Application No: BE/104/21/PL
Site Address: Land Adjoining the Tesco Express 351 Chichester Road Bognor Regis PO21 5AN
Description of works: Erection of 7 No. 2-storey dwellings consisting of 3 No. 2 bed units & 4 No. 3 bed units, access, parking, cycle storage, bin store and other associated landscape works. This site is in CIL Zone 4 & is CIL Liable as new dwellings.

Thank you for your internet representation made on 10th August 2021 which has been recorded as an objection with the comments as follows:

3 Front Elevation
1 : 50

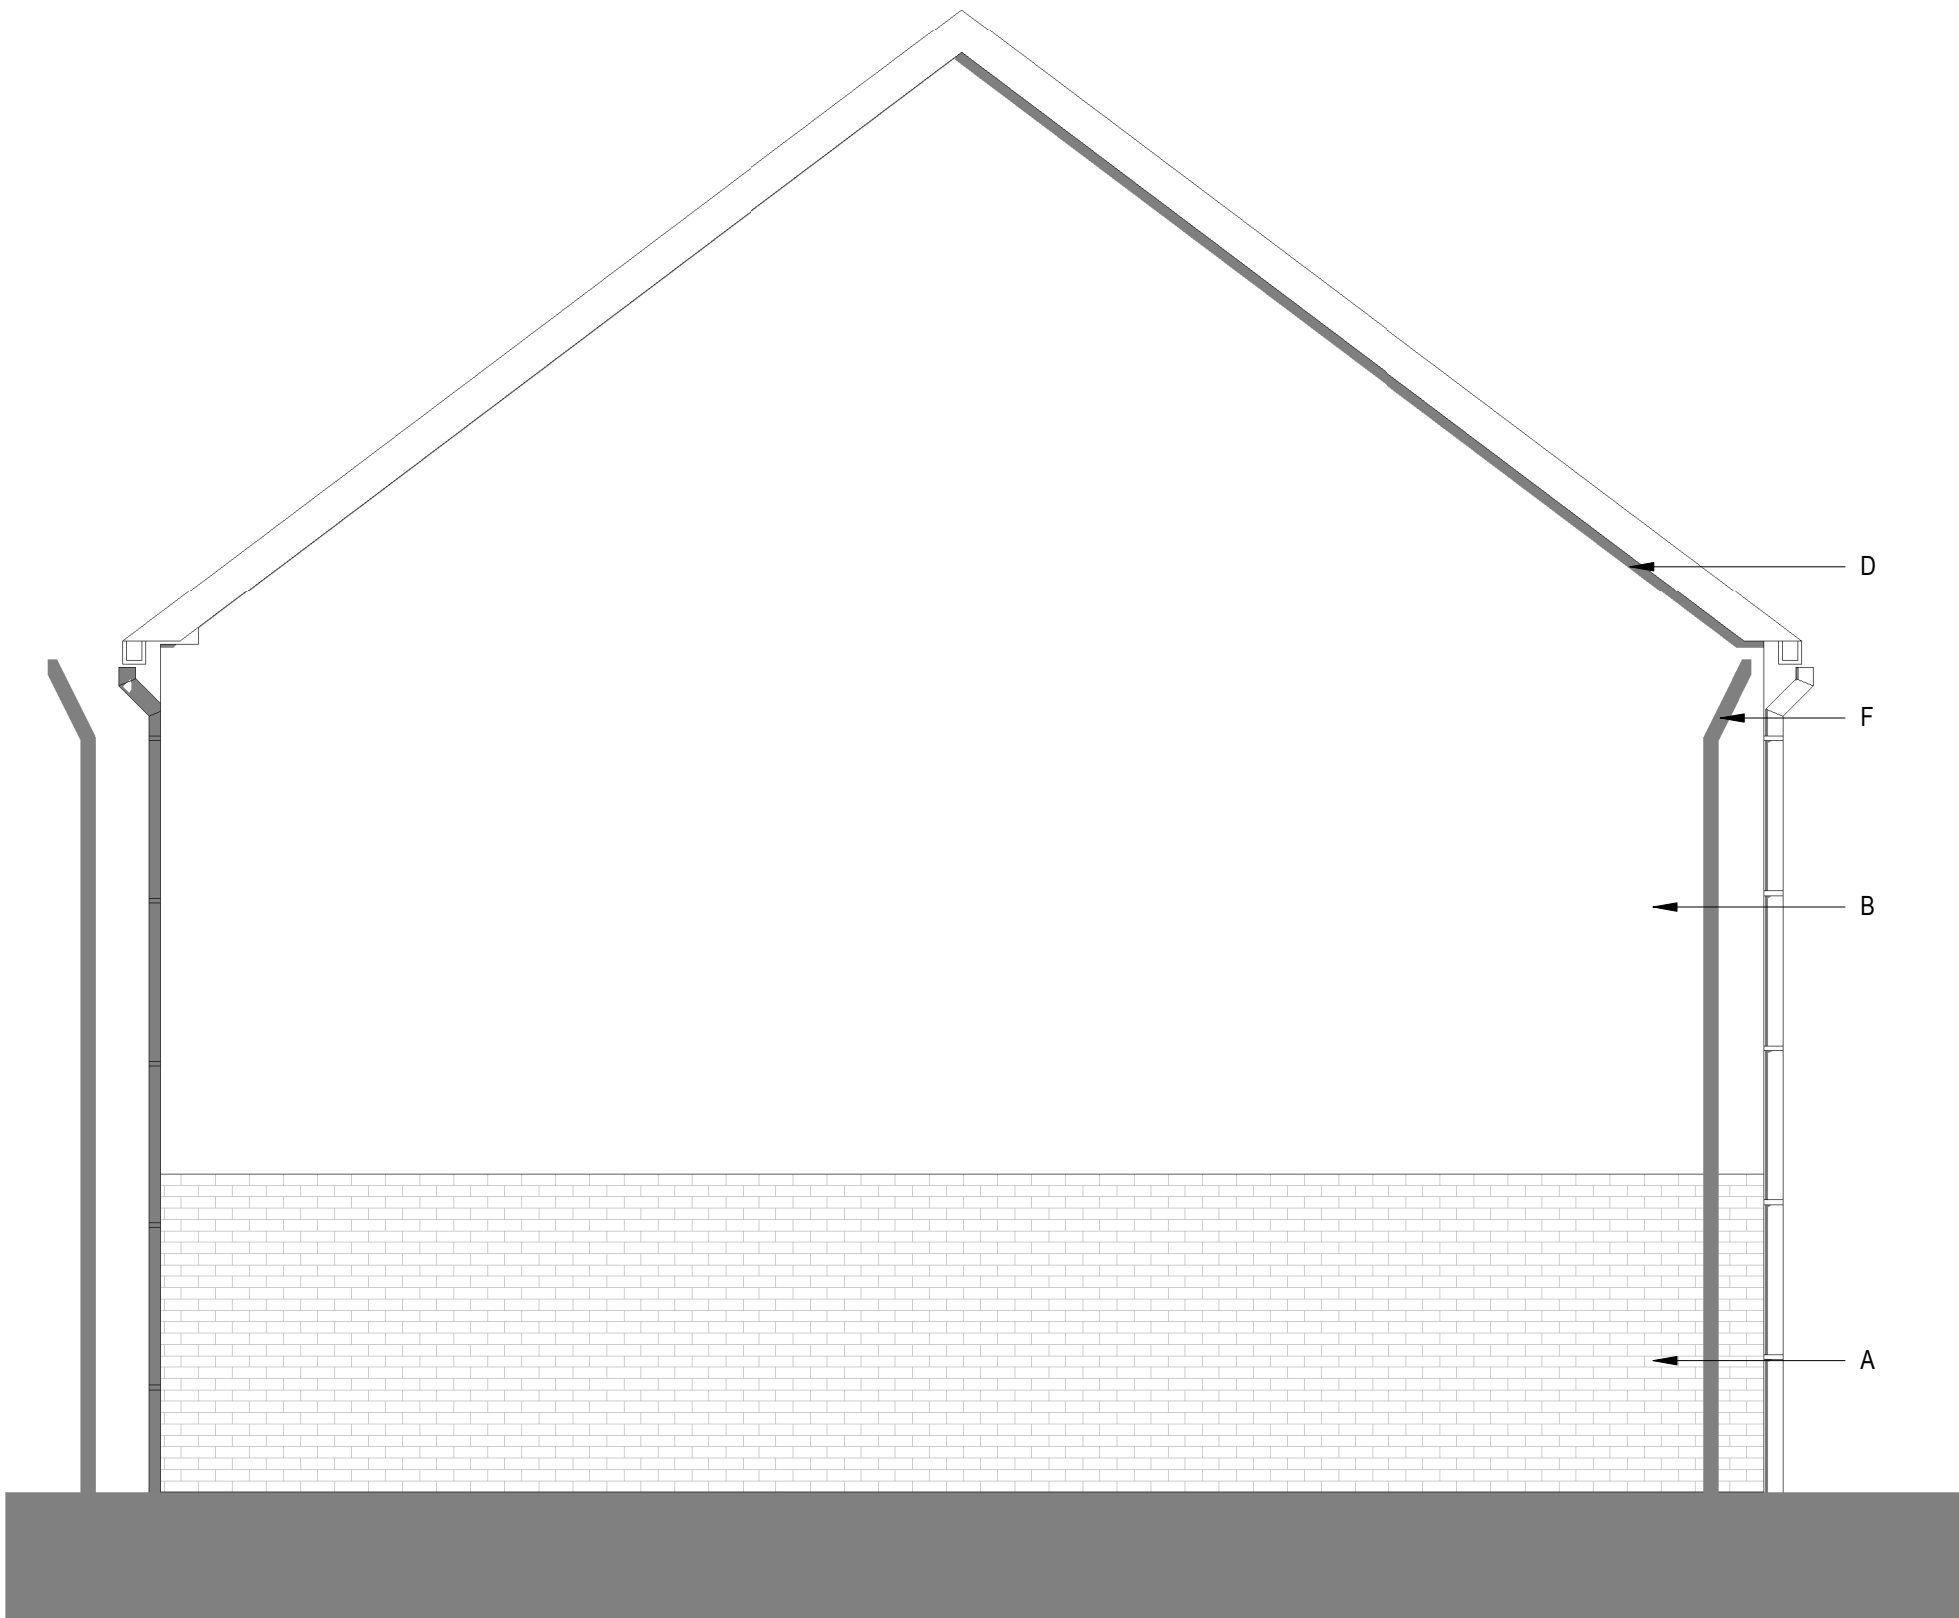
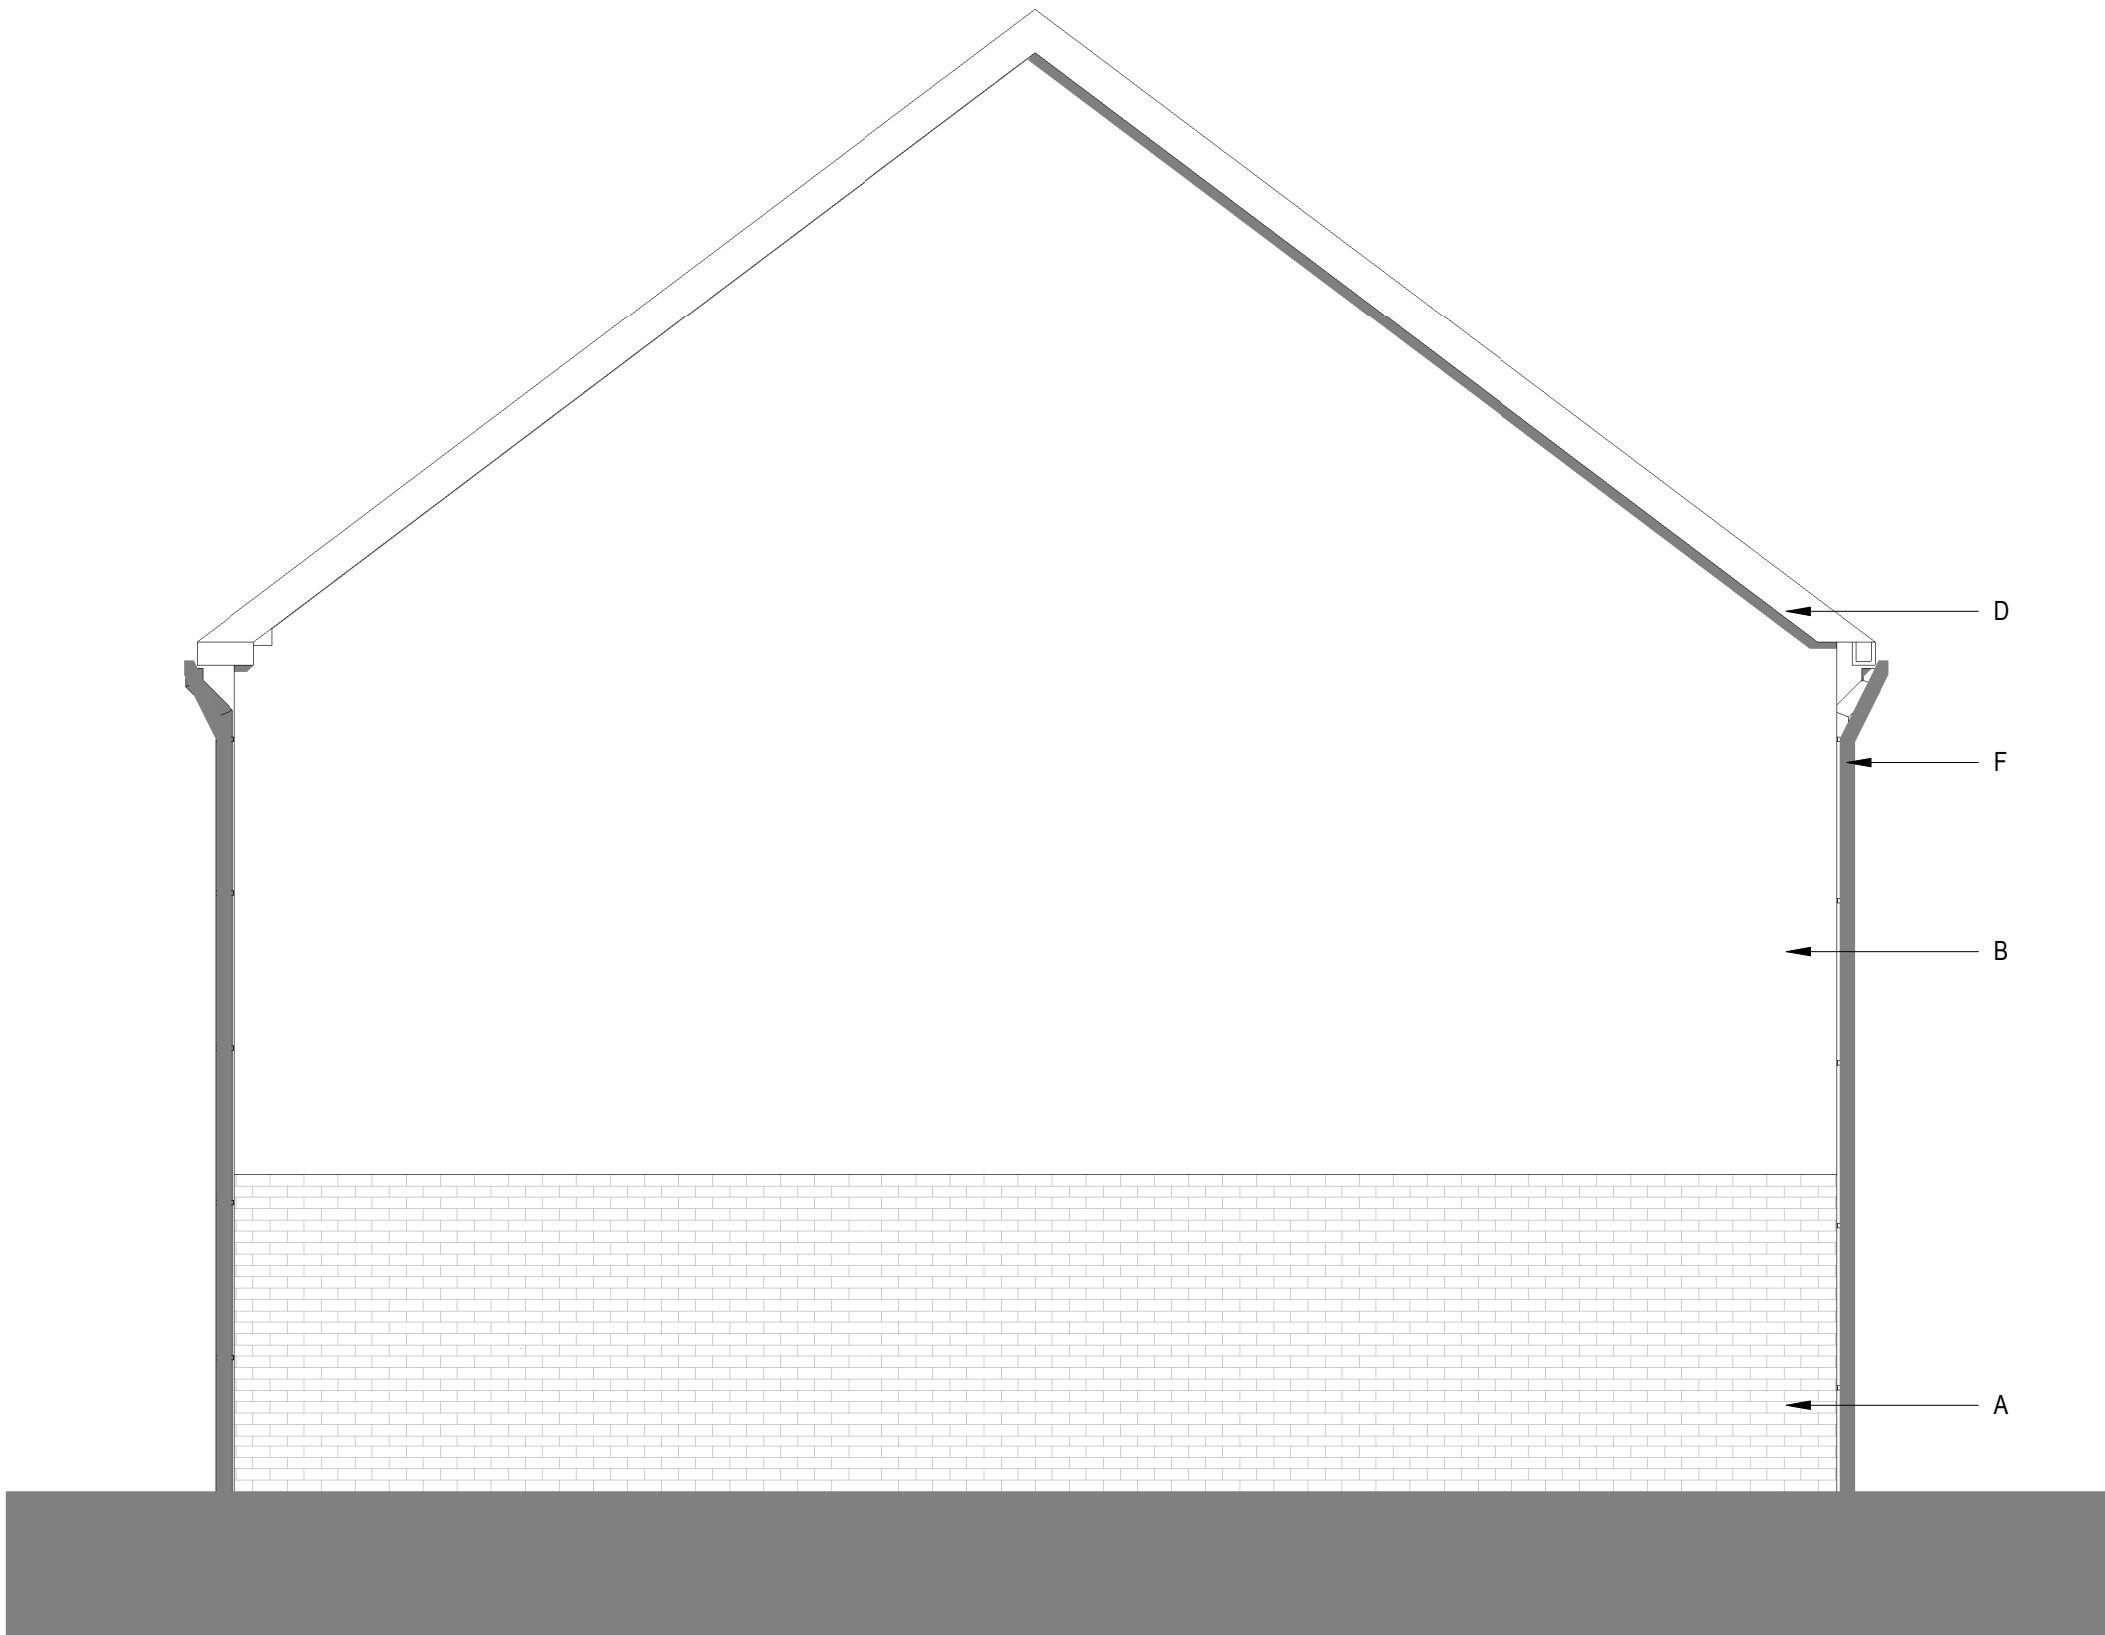
Proposed properties to rear of site are 3 story not 2 which will have a negative impact for residents in Bedford Avenue and Sun Park Close.
